Agreement - Land east of Tye Lane - 106 works - Walberton.

Please upload the email below from the Local Highway Authority, which is a consultation response to discharge of condition application **WA/18/20/DOC** - Land east of Tye Lane, Walberton.

Thank you for your email in relation to planning application WA/18/20/DOC that seeks the discharge of condition 4 (ped, cycle & emergency access point from Tye Lane) from planning permission WA/95/18/RES.

Client				
LINDEN HOMES SOUTH				
Project Title:				
LAND EAST OF TYE LANE, WALBERTON				
Drawing Title:				
PROPOSED OFF-SITE CULVERT WORKS				
A1 Scale		Date		Designed by
1:50		18.04.2019		JM
Drawn by		Checked by		Approved by
JM		JM		CH
Drawing Number		LHS240-1205		
		Rev T3

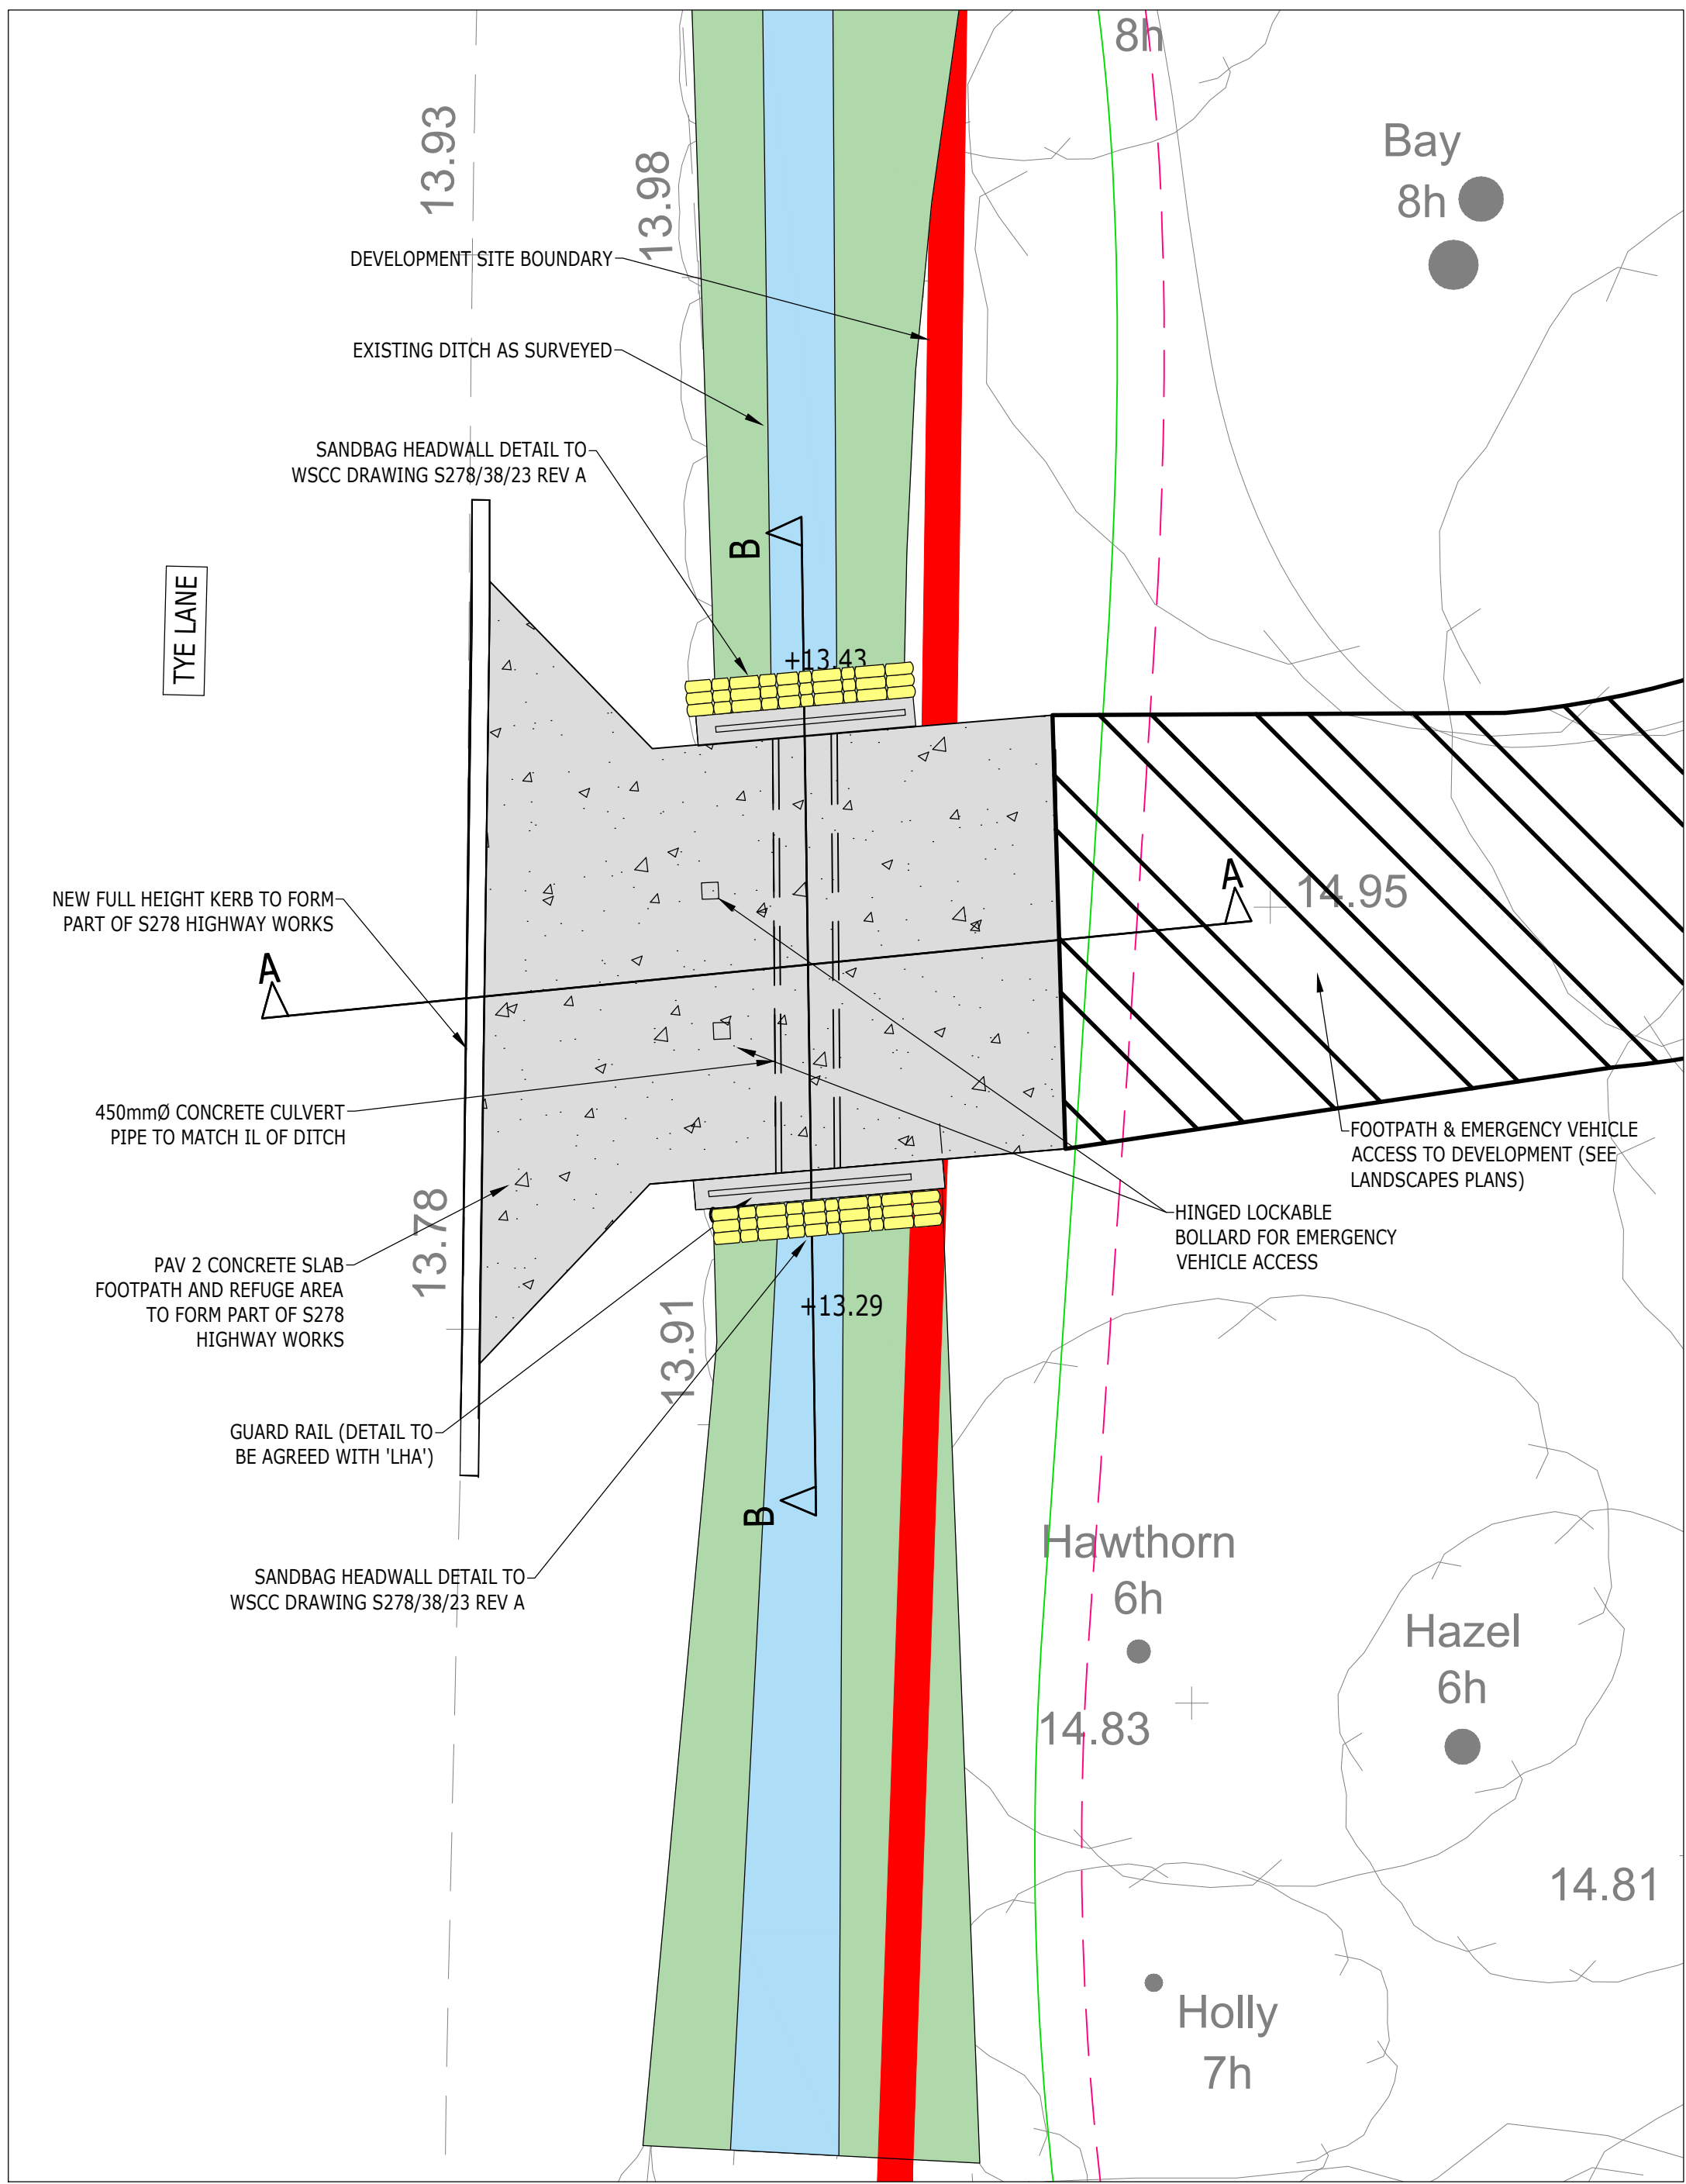
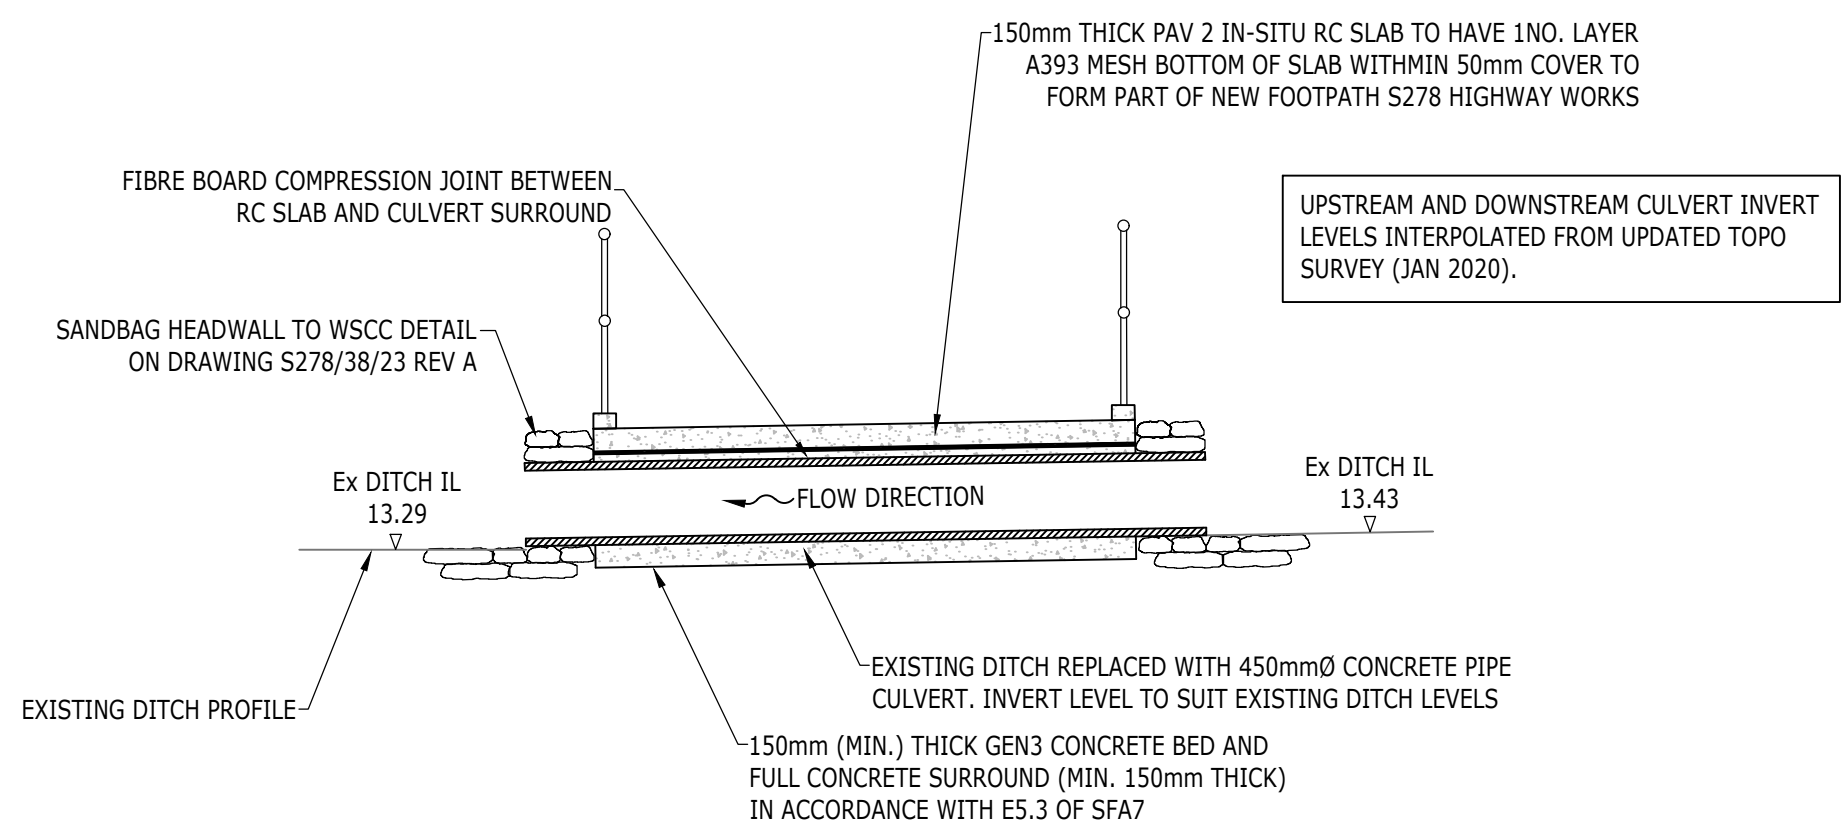
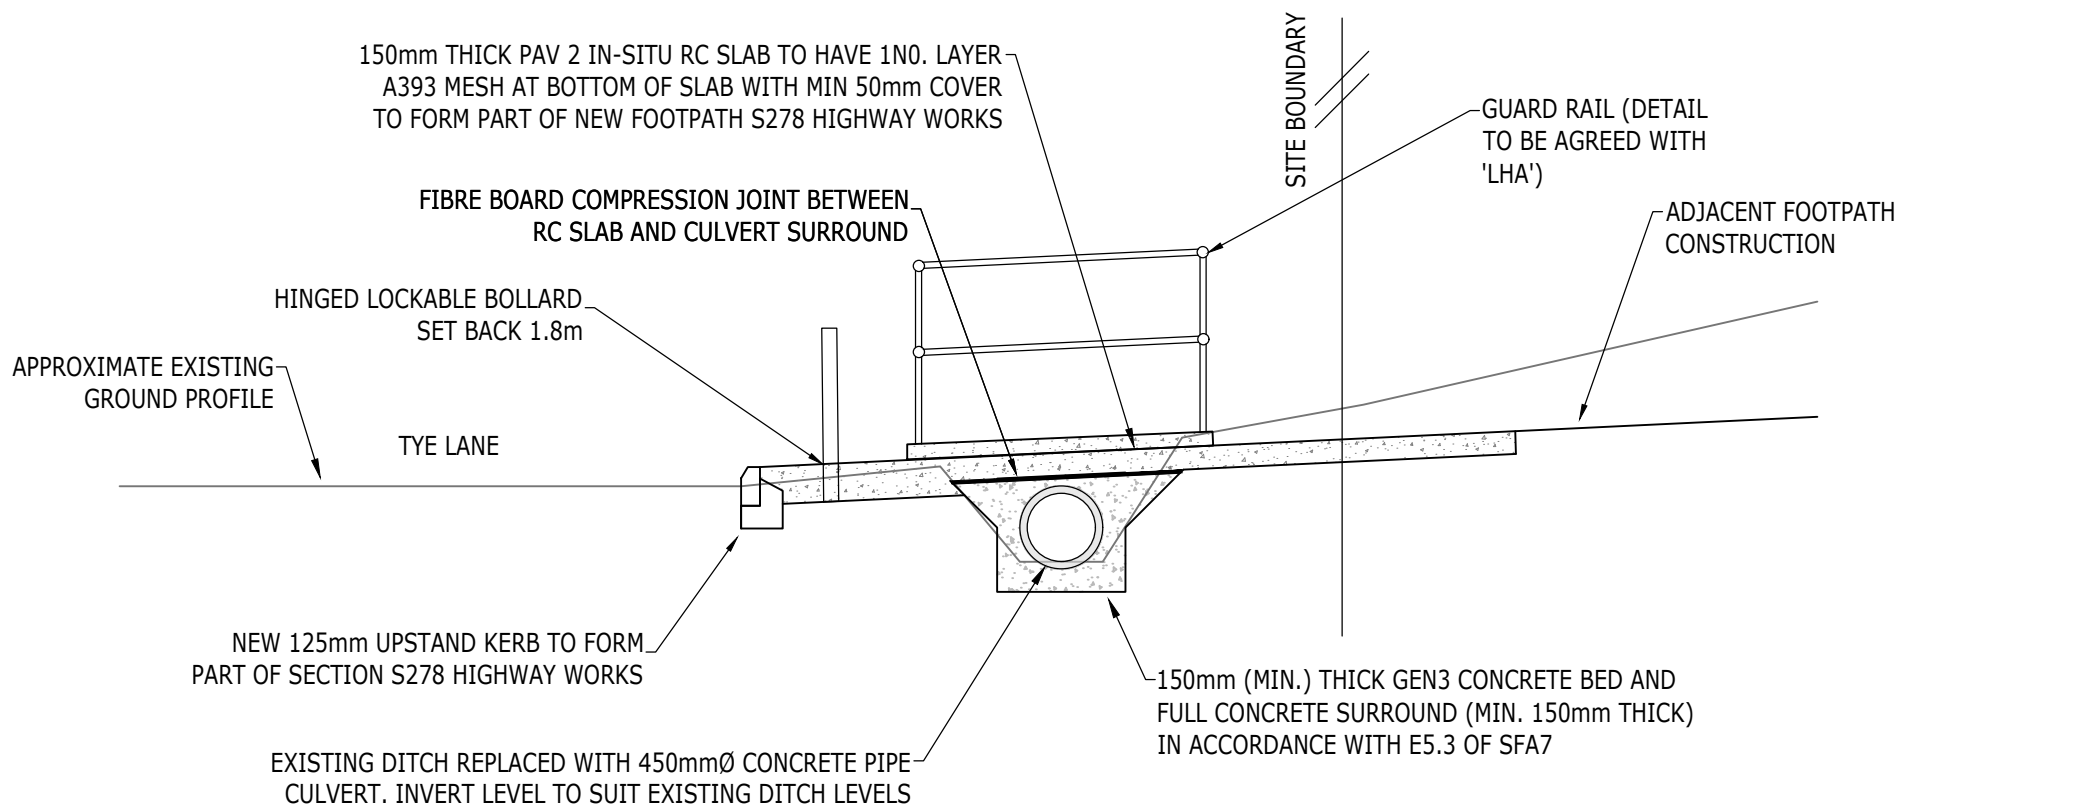
Your comments are noted in relation to detailed design following once discharge of condition is granted. Therefore based upon the submitted drawings WSCC as Highway Authority would not wish to object to planning application WA/18/20/DOC and the discharge of condition 4. It should be noted that you shall need to apply for all the necessary highway consents prior to undertaking any works upon the adopted highway. I am also aware that you are considering whether to use this access as a construction access point and this may require changes to the access to ensure a safe means of access for construction vehicles.

I've spoken to the engineer (Lee Moses) and the technical approval issued below does not include the emergency access from Tye Lane. As I understand no formal submission for technical approval has been received from the applicant for the emergency access from Tye Lane. Therefore we are not in a position to recommend discharge of the condition 4 relating to WA/95/18/RES as submitted by WA/18/20/DOC.

I also understand that because the applicant is now intending to use this as construction access that there may also be a need for a change to the design of this access.
